Rezoning Transportation Analysis
Petition Number: Insert Zoning Petition #2021-216
General Location Identifier: 02956107

From: Brandon Brezeale, PE
Brandon.Brezeale@charlottenc.gov
704-432-5561

Date	Description
01-24-2022	First Review (PDM)
02-24-2022	Second Review (PDM)
03-30-2022	Third Review (PDM)

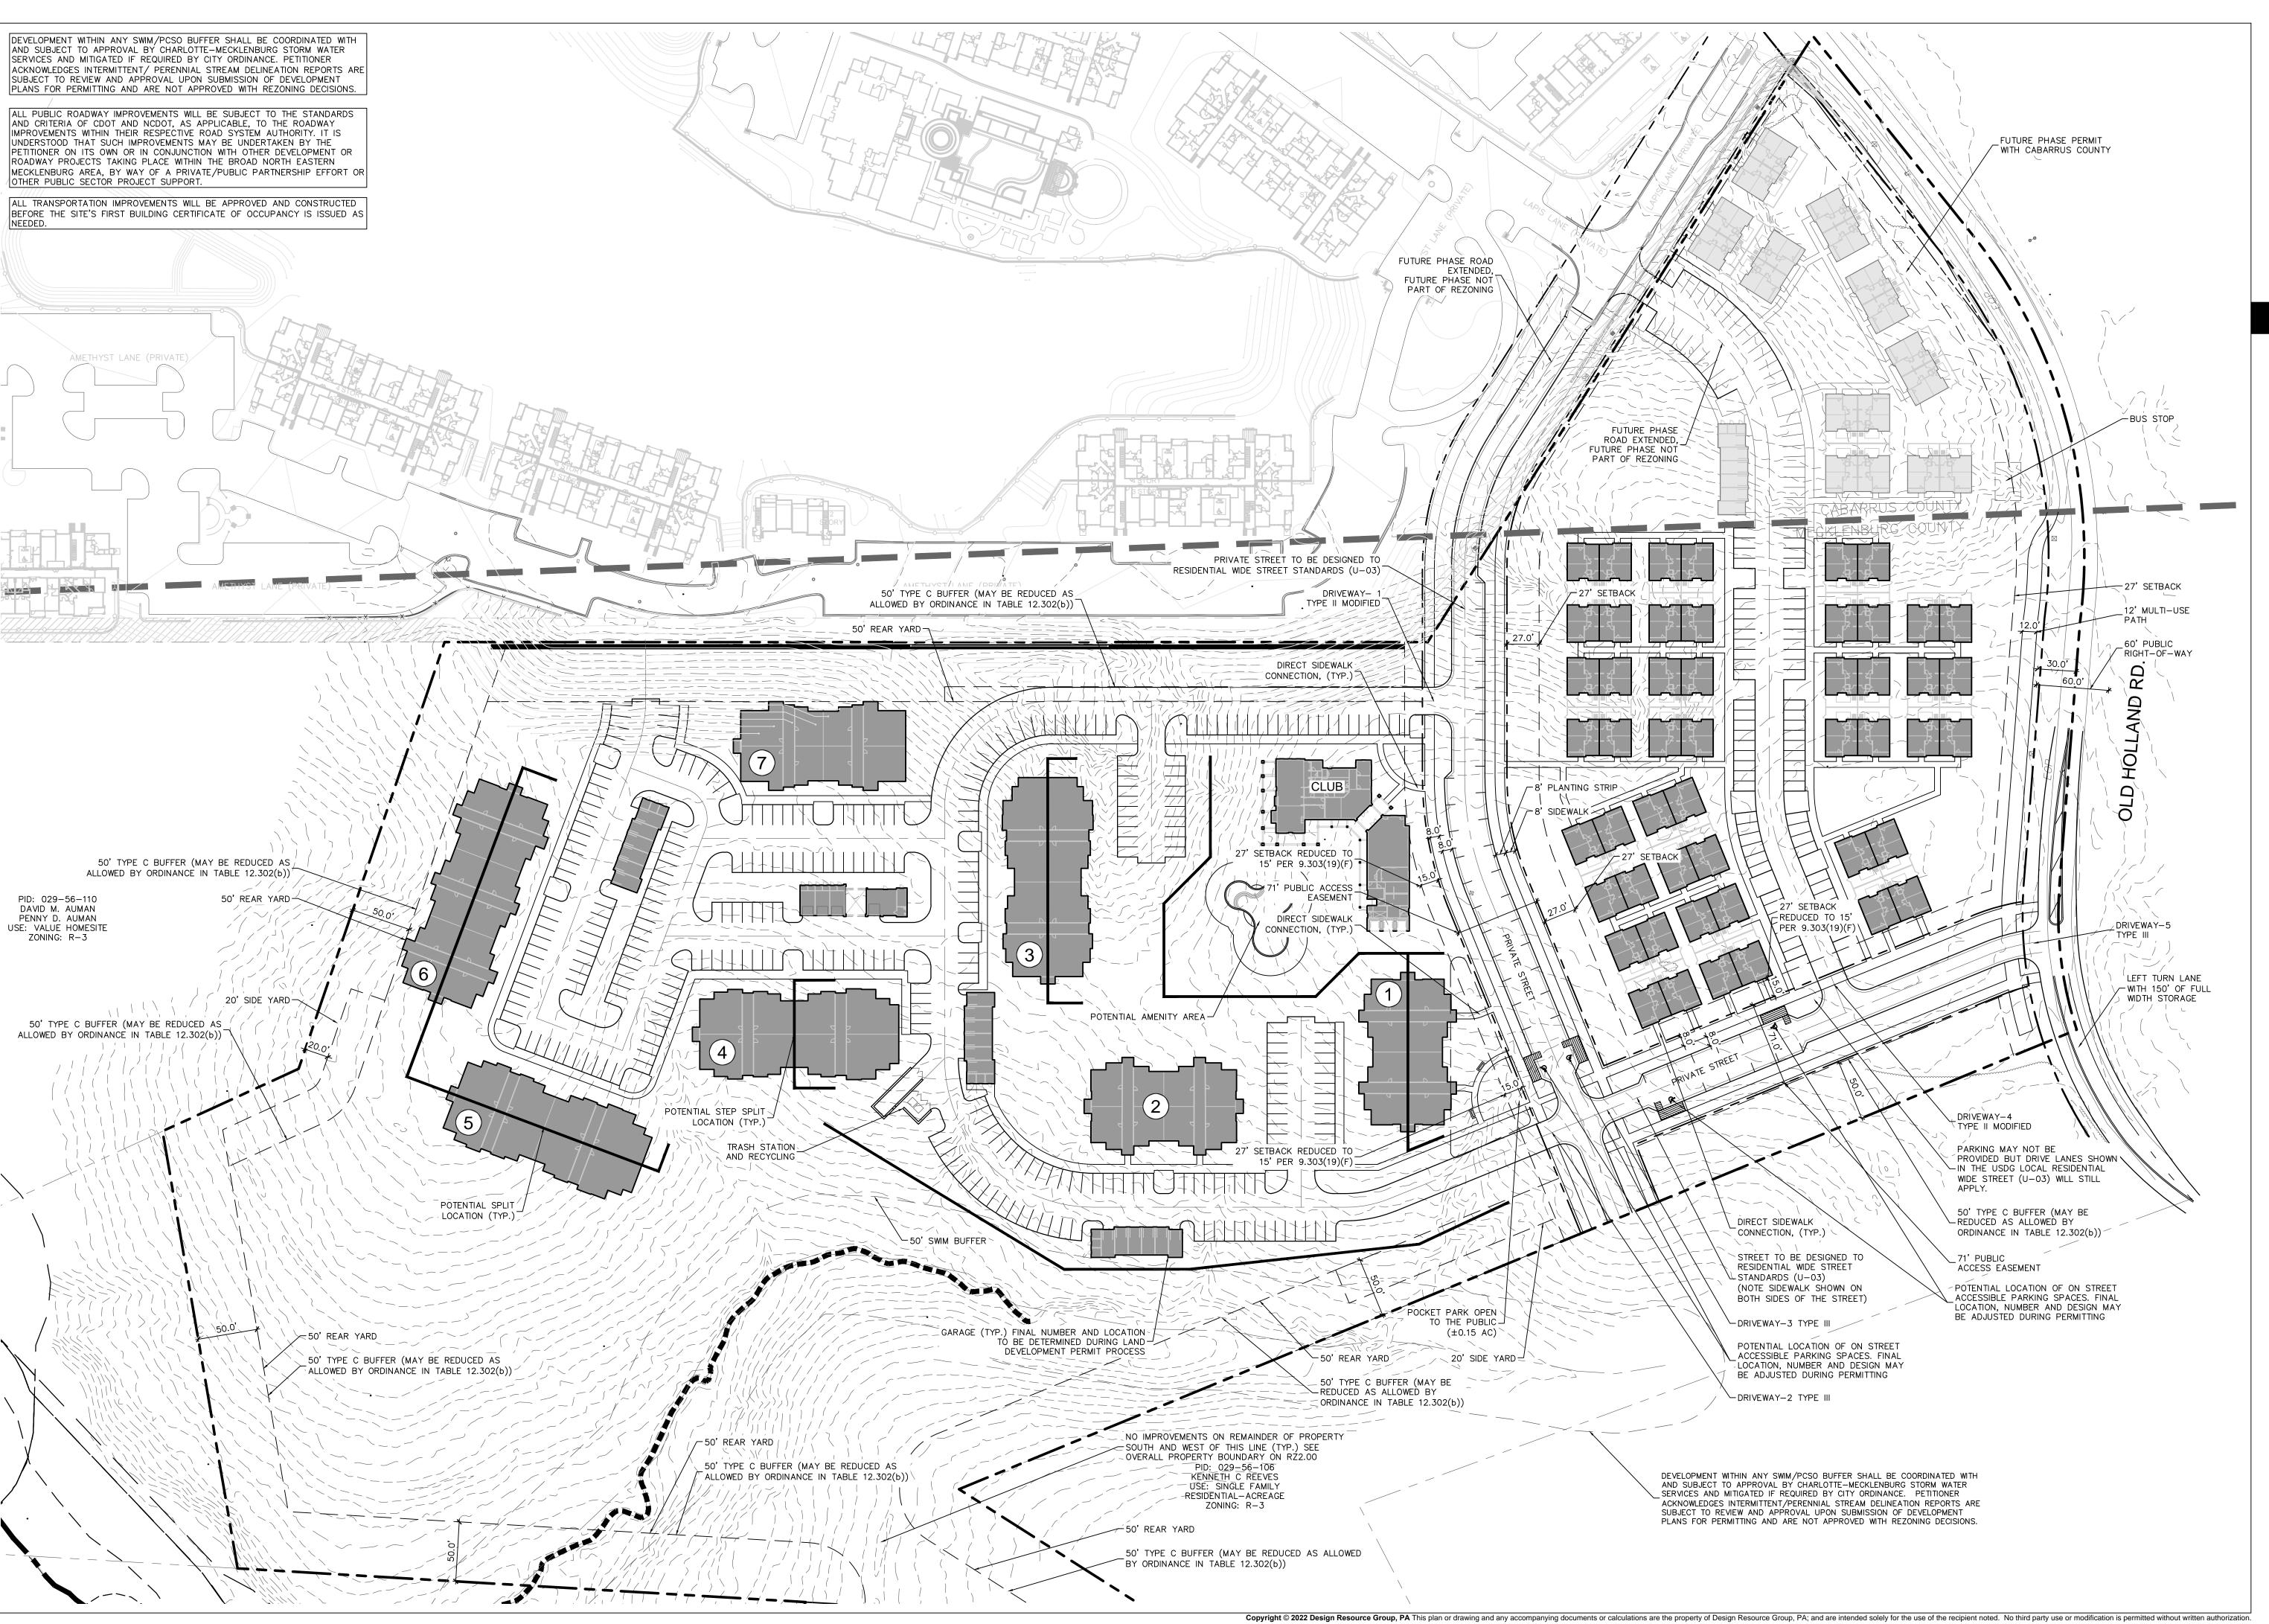
10. ~~Rescinded Comment from 01.24.2022:~~ Revise site plan to provide a public street or private street with public access easement to the western edge of the property.

11. Revise site plan to provide ADA ramps to cross the internal street at the intersection of Old Holland Road. The street connection should be designed as an intersection and not a Type III driveway.

12. Revise site plan to provide ADA ramps to cross the internal streets at all internal intersections and driveways.
13. Provide clarification to what is planned for the undeveloped portion of the parcel to the south side of the development. Consider subdividing the parcel to remove this portion from the development. Additional right-of-way may be requested for a future public street in this area based upon the provided clarification.

15. A site plan note specifying that all transportation improvements will be approved and constructed before the site's first building certificate of occupancy is issued as needed. The petitioner may phase transportation improvements if said improvements and phasing are explicitly described in site plan notes.

- ~~Clarifying comment from 02.24.22:~~ Remove "under this section C of the development standards for note C.7. because all the required transportation improvements are not listed under section C such as the 12-foot multi-use path on Old Holland.
